Name	Company	Email	
То	Allisan Serra	Savills Project Management	aserra@savills.com.au	
Cc	Ramin Jahromi	Cox Richardson	Ramin.Jahromi@cox.com.au	
	Shelani Perera	Cox Richardson	Shelani.Perera@cox.com.au	
	Frank de Pasquale	Philip Chun & Associates	Frank.DePasquale@philipchun.com	
Date	21/05/2015	Job no SY130111	Version CA1.0	
Project	161 Sussex Street, Sydney – Rooftop bar and lounge

This advice relates to the proposed extension of the existing northern hotel tower at 161 Sussex Street, Sydney to incorporate a bar and lounge on levels 11 and 12. These areas have been classified as a class 6 in accordance with clause A3.2 of the National Construction Code Series 2015 Volume One – Building Code of Australia (BCA)¹. Defire has undertaken a preliminary fire safety engineering review of the proposed design for the development application submission at the request of Savills Project Management.

Drawing Title:
EXECUTIVE BAR - LEVEL 12

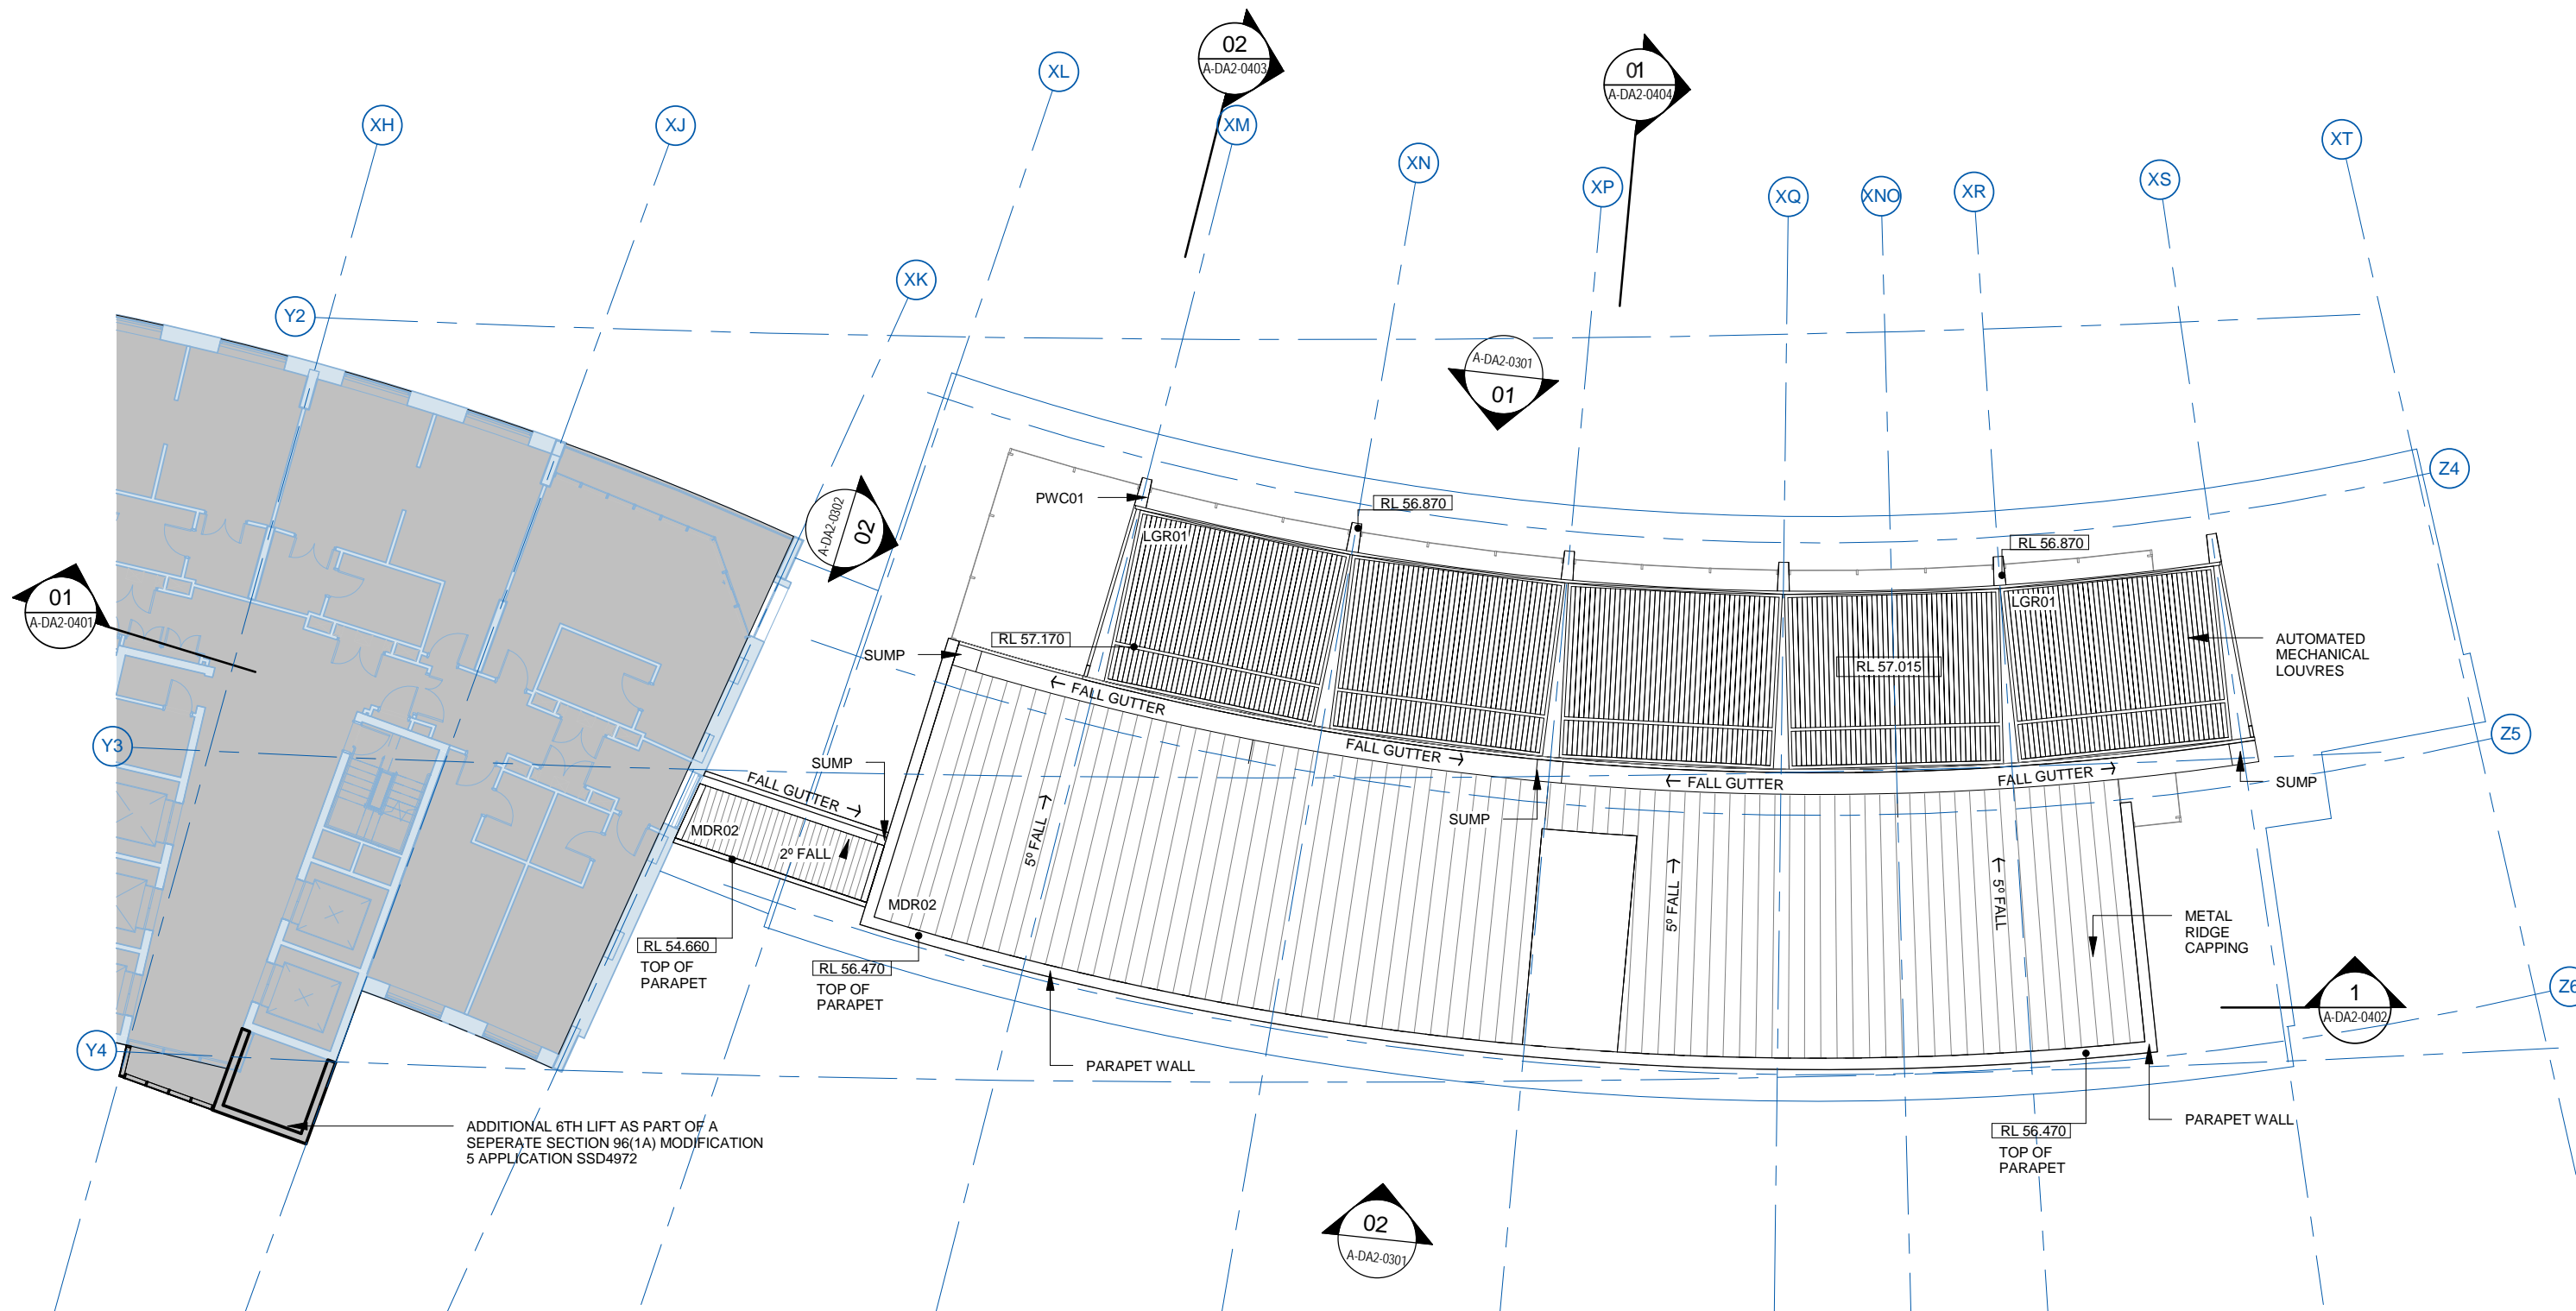
No	Description of alternative solutions	DTS provision	Performance requirements
1.	The rooftop bar and lounge on levels 11 and 12 are not proposed to be provided with a zone smoke control system in accordance with AS/NZS 1668.1:1998.	Clause E2.2 and table E2.2a	EP2.2

3. The new bar and lounge must be fire separated from the existing hotel portions on levels 11 and 12 in accordance with clause C2.8 of the BCA. The FRL achieved by the separating wall is to be not less than 180/180/180. Doors in the fire wall self-closing or automatic-closing and achieve an FRL of -/180/30. The doors must swing in the direction of egress.

4. The bar and lounge on levels 11 and 12 is not required to be provided with a zone smoke control system.
